**Consultation Response from KC,  
Highways Development Management**

**2024/91828 Premier Inn, St Andrew's Road, Huddersfield, HD1 6SD**

**Demolition of existing hotel restaurant and erection of additional hotel bedrooms with breakfast room and alterations to the car park and associated works**

**Date Responded: 12/12/2024**

PROPOSED SITE PLAN  
SCALE 1:500

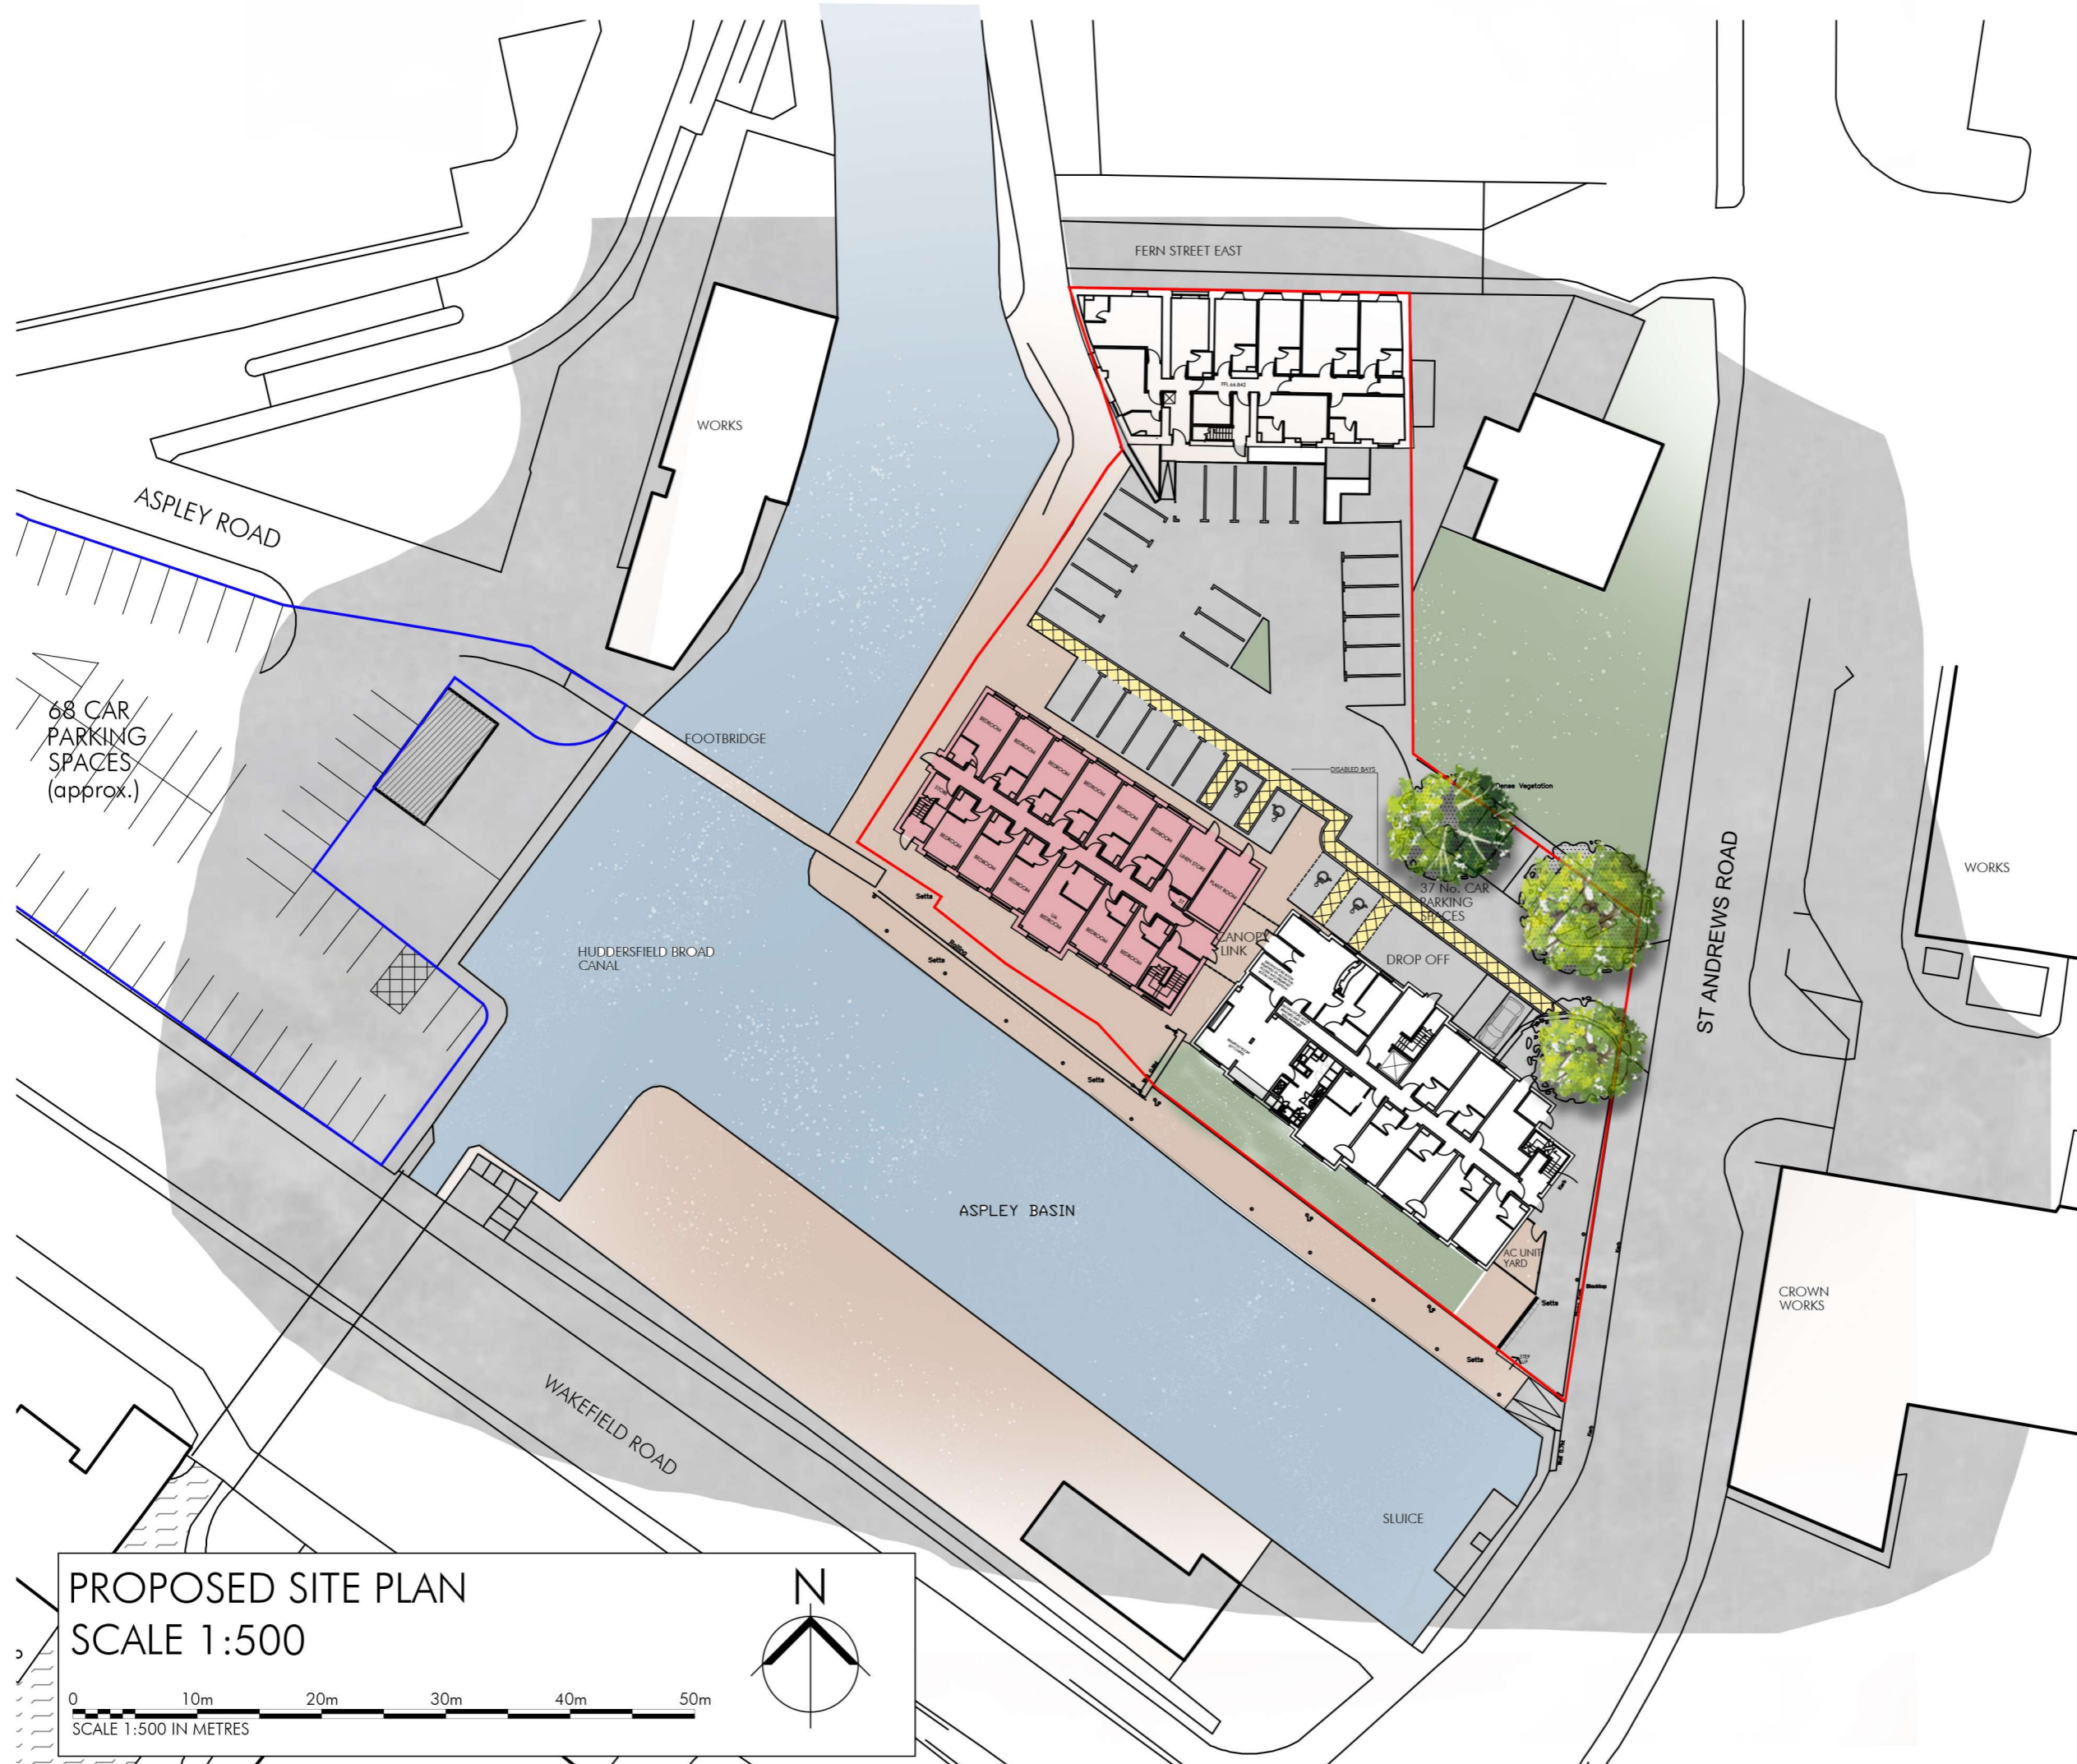
It is proposed to access/egress the site via the existing arrangements with one access onto St Andrews Road and a further access via shared point with sainsburys supermarket onto Wakefield Road. No further works are proposed or required to accommodate the proposals in this respect.

The existing parking provision to serve the hotel and Restaurant has a total of 90 car parking spaces which is controlled via automatic number plate recognition. The proposed parking provision is to be increased to 106 parking spaces. To determine the level of parking required a parking accumulation assessment has been carried out, this sets out that the level of parking at peak demand has a peak accumulation of 73 vehicles which equates to an 81% capacity. Given the removal of the restaurant element which is considered to generate the majority of parking demand, the forecast parking provision is considered to be of an acceptable level.

The building shall not be brought into use until the proposed car park hereby approved shall be laid out surfaced, marked out into bays and drained in accordance with details that have previously been approved in writing by the Local Planning Authority.
